APPENDIX K: ASPECT INDUSTRIAL ESTATE SSD – 10448 RFI RESPONSE

Submission	Comment	Response
DPIE - Industry Assessments and Central (Western) Team		
1.1	<p>The proposed Access Road 1 is identified as a higher order road in the draft Mamre Road Precinct Development Control Plan (MRP DCP) as it provides a key controlled access location to Mamre Road for the development and future developments to the north, east and south of the site.</p> <p>The draft MRP DCP identified a required road width of 30.6 m at the Mamre Road/Access Road 1 intersection with a potential midblock width reduction to 26.4 m, subject to design and Council agreement.</p> <p>The road is also 'accessed denied' meaning car park access and loading dock access should not be provided to/from this road.</p> <p>The Department notes the width of Access Road 1, car park and loading dock entries/exits at Access Road 1 are retained. The development does not achieve the nominated width and includes direct access from warehouses 1 (Stage 1 development) and 8 (Concept Proposal).</p> <p>The Department also notes TfNSW raised concerns about locating the access for the car park to the west of the café close to the proposed Mamre Roa

S1 Estate Pylon Sign
Artwork & colour to future detail.
Illuminated

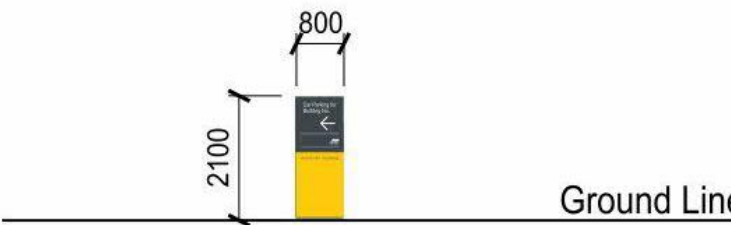
2.4	(3) Council reiterates that the proposed height of the estate pylon signs as originally lodged is excessive, and these should be reduced in height or deleted altogether as an unnecessary signage feature. At the very least, only one estate pylon sign should be provided. The applicant has not sufficiently responded to this concern, citing considerations in SEPP 64 which are not considered to prevail or prevent considerations relating to streetscape presentation or landscape integration."	The proposed pylon signs are deemed appropriate given their context within an industrial estate. As part of this RFI response and as detailed in the Amended Development Report the pylon signage has been reduced in height from 12m to 11m. It is important to have clear and legible signage to mitigate risk of accidents and ensure enhanced safety through way finding. Penrith Council stated within their original submission "Appropriate signage, visible from the public roadway and on-site, shall be installed to reinforce designated vehicle circulation and to direct staff, delivery vehicle drivers, service vehicle drivers and visitors to on-site parking and delivery and

service areas". The proposed signage is deemed to satisfy this requirement.
2.5	Councils Section 7.12 Citywide Contribution Plan is currently applicable to this site. Please note that an amendment to this plan was exhibited in November 2020 to remove the applicability of this plan from the Mamre Road Precinct. This amendment is yet to be determined and may impact the determination of this application.	Noted. It is proposed that the applicable Local Contributions Plan at the time of determination will apply to the AIE SSD Stage 1 development with subsequent stages subject to the relevant Local Contributions Plan applicable at time of determinations.

OPTON 1 - CONFIG#26 SWAMP FOREST INFILTRATION TO DEEP SOIL

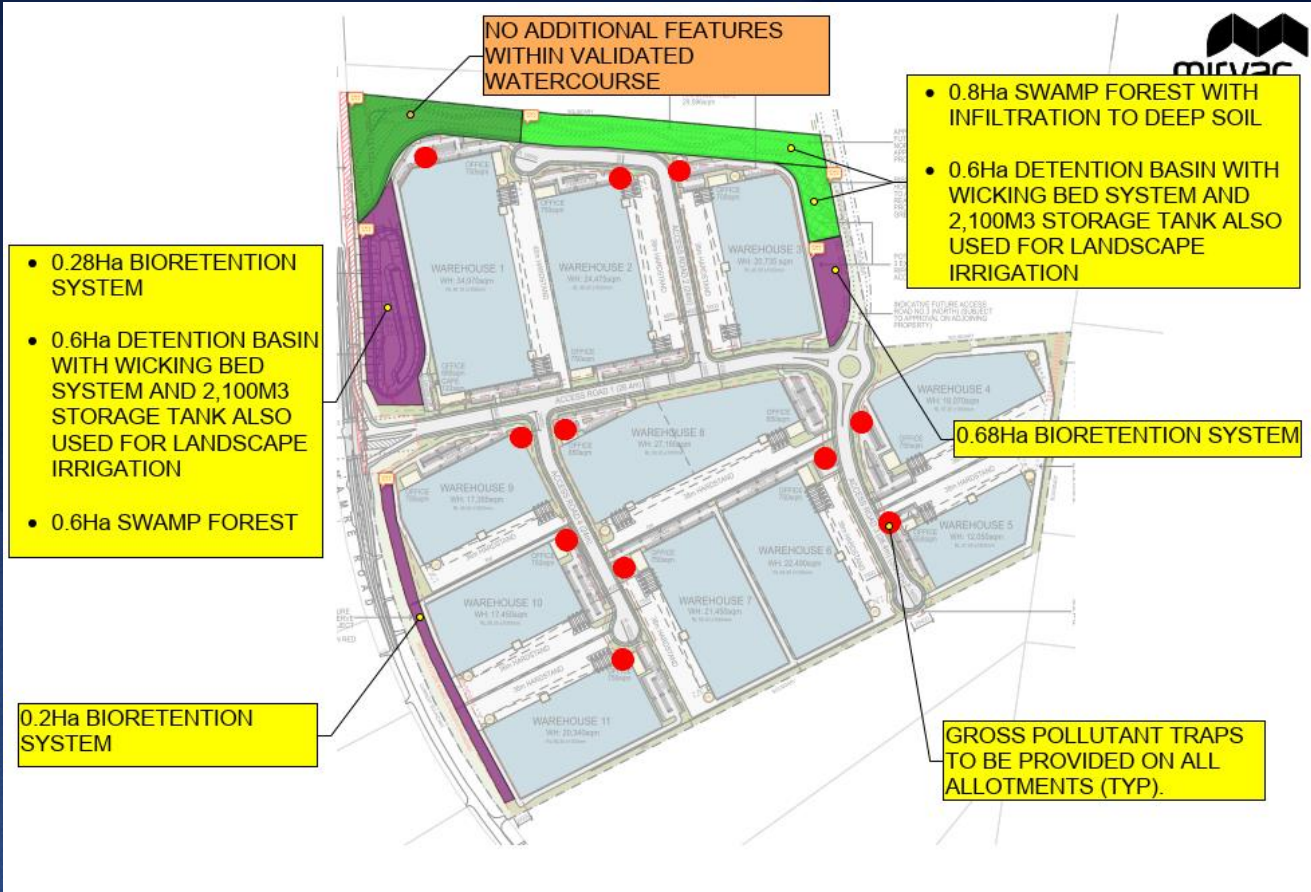
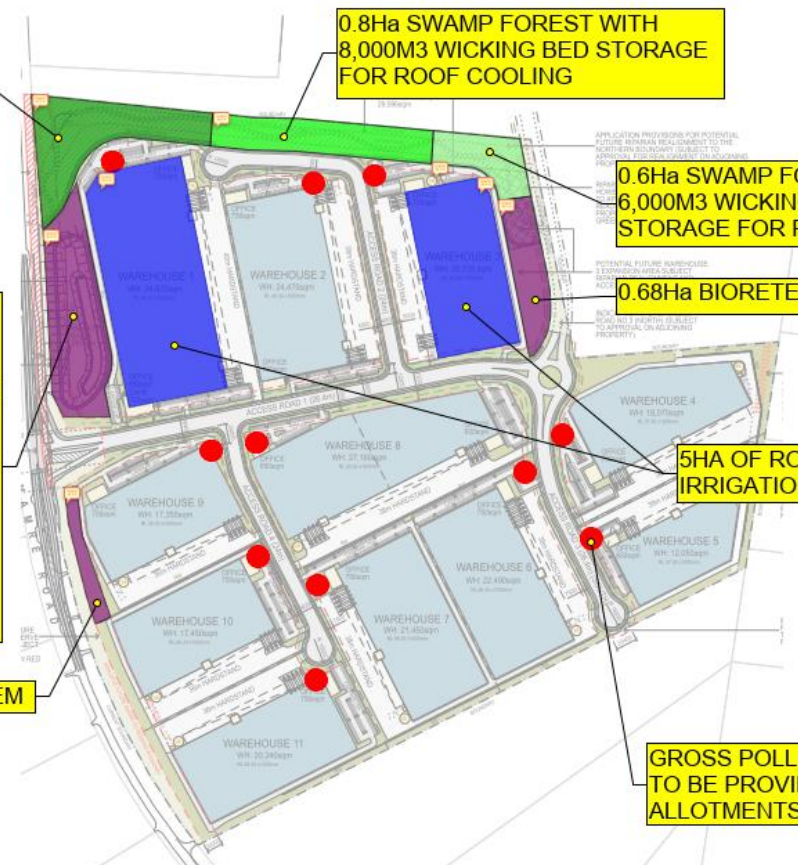
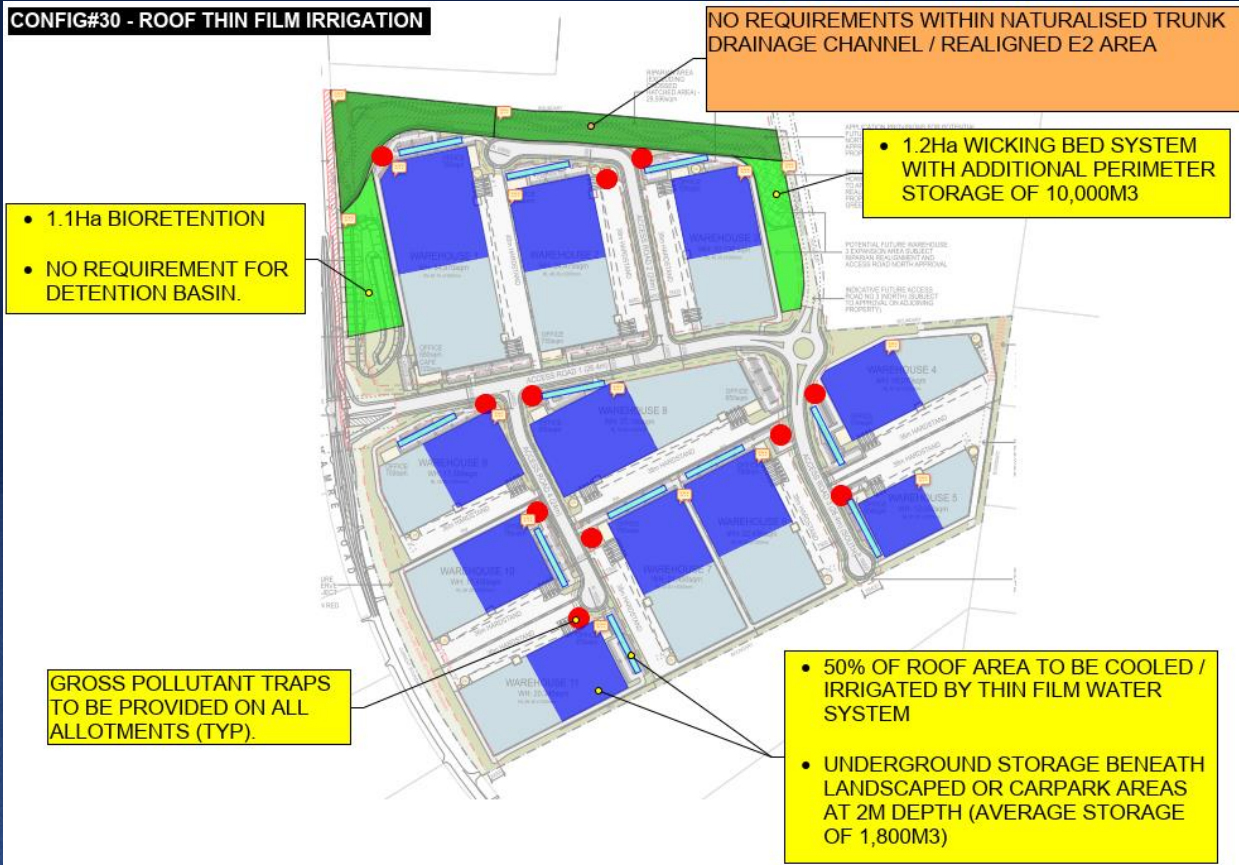
1.16	<p>"The draft MRP DCP adopts the EES Group, DPIE approach to water quality and flow related objectives for the Wianamatta-South Creek catchment. The Department's Central (Western) team note that reliance on a "regional approach" is still under investigation and is subject to further consideration.</p> <p>The Supplementary RtS should clarify how the proposed water management system will achieve the draft MRP DCP waterway health outcomes, rather than relying on a regional approach, which has not been confirmed."</p>	<p>Since the RTS package was submitted to the Department the MRP DCP was adopted (19 November 2021). The MRP DCP along with the Operational phase targets as set within the <i>MUSIC modelling toolkit – Wianamatta (20 April 2022)</i> (MUSIC toolkit) as prepared by the <i>Environmental and Heritage Group</i> (EHG) of the <i>Department of Planning and Environment</i> provides the waterway health requirements to be met either on-lot, estate, catchment or a regional solution.</p> <p>1.1.1. Waterway Health – Stage 1</p> <p>In-lieu of a regional solution, Mirvac has provided AIE Stage 1 waterway health documentation to demonstrate an estate-based solution to compliance with the Operational phase targets as set within the <i>MUSIC modelling toolkit – Wianamatta (20 April 2022)</i> (MUSIC toolkit) as prepared</p>

<p>by the <i>Environmental and Heritage Group (EHG)</i> of the <i>Department of Planning and Environment</i>.</p> <p>The Stage 1 proposal has demonstrated compliance with the MUSIC toolkit operational phase stormwater quality targets Option 2 – allowable loads and the <i>operational Phase stormwater quantity (flow) targets option 1 – MARV</i>.</p> <p>Mirvac understand that DPIE have no further comments on the Stage 1 waterway health proposal.</p> <p>Reference plan for the AIE Stage 1 waterway health solution is included within Appendix J.</p> <p>Waterway Health – Concept Masterplan</p> <p>Mirvac has provided three (3) potential waterway health estate-based configurations to demonstrate compliance with the <i>MUSIC modelling toolkit – Wianamatta (20 April 2022)</i> (MUSIC toolkit) as prepared by the <i>Environmental and Heritage Group (EHG)</i> of the <i>Department of Planning and Environment</i>.</p> <p>Each option demonstrates an estate scale waterway health solution to demonstrate compliance with the waterway health objectives whilst supporting the Concept Masterplan.</p> <p>A detailed package of Options 1 – 3 (inclusive) including associated MUSIC modelling files and post processing spreadsheet documentation was provided to the Department in February 2022. This package of work demonstrates that the current AIE concept masterplan is capable of support with multiple options available to achieve waterway health objectives at an estate scale without amendment to the current AIE concept masterplan. Mirvac understands that DPE have no further comments on the Concept Masterplan waterway health proposals at this stage.</p> <p>Following DPE review, Mirvac understands that the following elements have been endorsed in principle:</p> <ul style="list-style-type: none"> ▪ Utilisation of the non-validated portion of the re-aligned watercourse for swamp forest to provide a detention and evapotranspiration solution as

<p>set out in Options 1 & 2 is approved in principle by NRAR, EES & IDC (& DPIE) however this is subject to confirming that the site-specific infiltration rates are field validated as being appropriate based on ground conditions and do not pose a salinity risk to the satisfaction of DPIE; and</p> <ul style="list-style-type: none"> ▪ Utilising ‘thin film’ irrigation as set out in Options 2 & 3 which could be scaled to be applied to one or more buildings and delivered on a staged basis as part of the overall estate solution <p>Reference plans for the AIE Concept Masterplan waterway health solutions are included within Appendix J.</p>
